Megan Webb - MP08_0172 Royal North Shore Hospital - s75W Modification to Community Health Building

From: "Tony Robb" <trobb@urbis.com.au>
To: <megan.webb@planning.nsw.gov.au>
Date: 14/12/2009 09:26
Subject: MP08_0172 Royal North Shore Hospital - s75W Modification to Community Health Building
CC: "Alix Carpenter" <Alix.Carpenter@planning.nsw.gov.au>, "Robert E. Lee" <RELee@thiess.com.au>, "Mahn England" <mengland@thiess.com.au>
Attachments: CTLCXBL02_2009-12-11.pdf

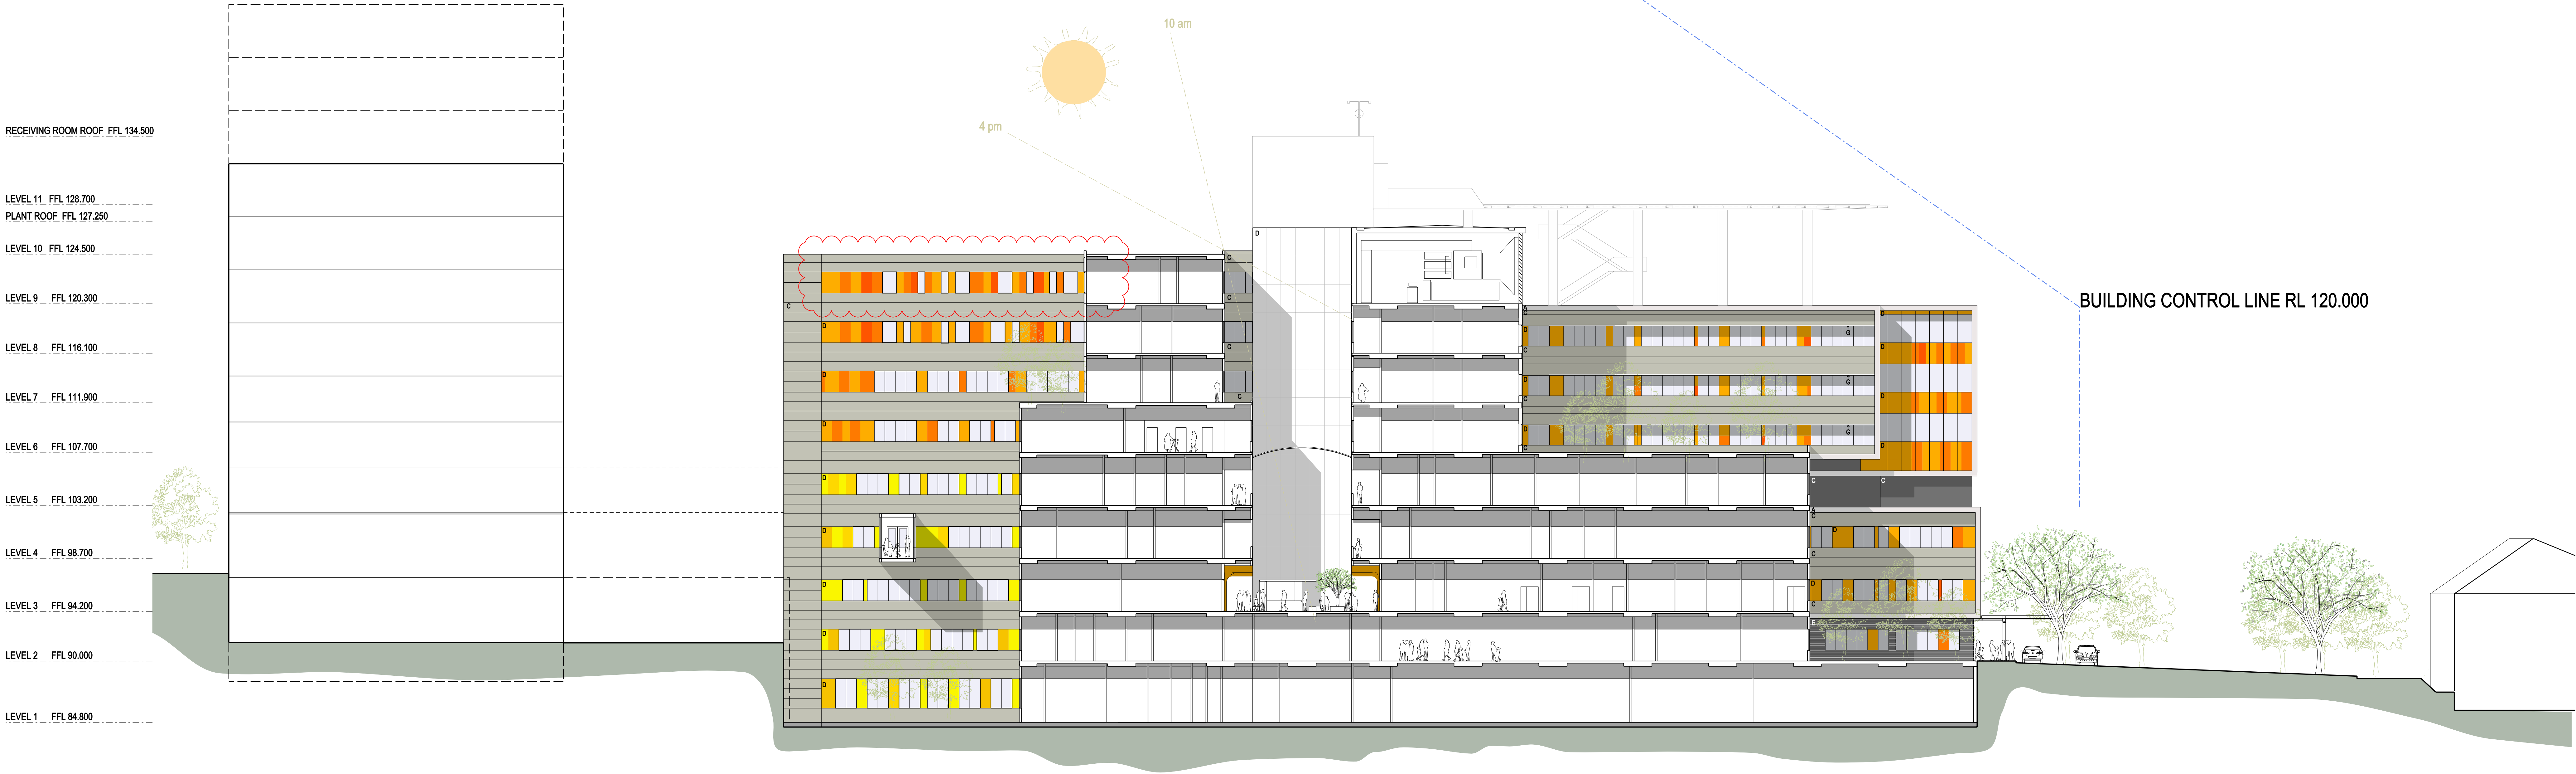
1. Whether the height of the now approved development and the modified scheme has been measured consistently?
2. What is the Gross Floor Area of the approved building and the modified building?
3. Whether, given changes to the vehicular access arrangements to the building; that any necessity arises for pedestrian crossing or the like?

1. In the context of this assessment, height is addressed through the application of a "Height Control Plan", as included under the Concept Plan approval for the site. The maximum finished level for any building on the site ranges between RL110 and RL140. Compliance in this respect is therefore achieved if the building is located within this envelope. To answer the question directly, the building has not been described or assessed in terms of "building height" but has rather been assessed against the maximum Raised Levels as provided in the Height Control Plan.

The proposed modified scheme represents an increase in height of 1.6m, making the new finished level RL114.6. As demonstrated at Drawing No DWG-CH-AR-00402 accompanying this application, a height control line has been created to follow the increasing maximum height level as one moves west away from Herbert Street and the building will sit within this envelope.
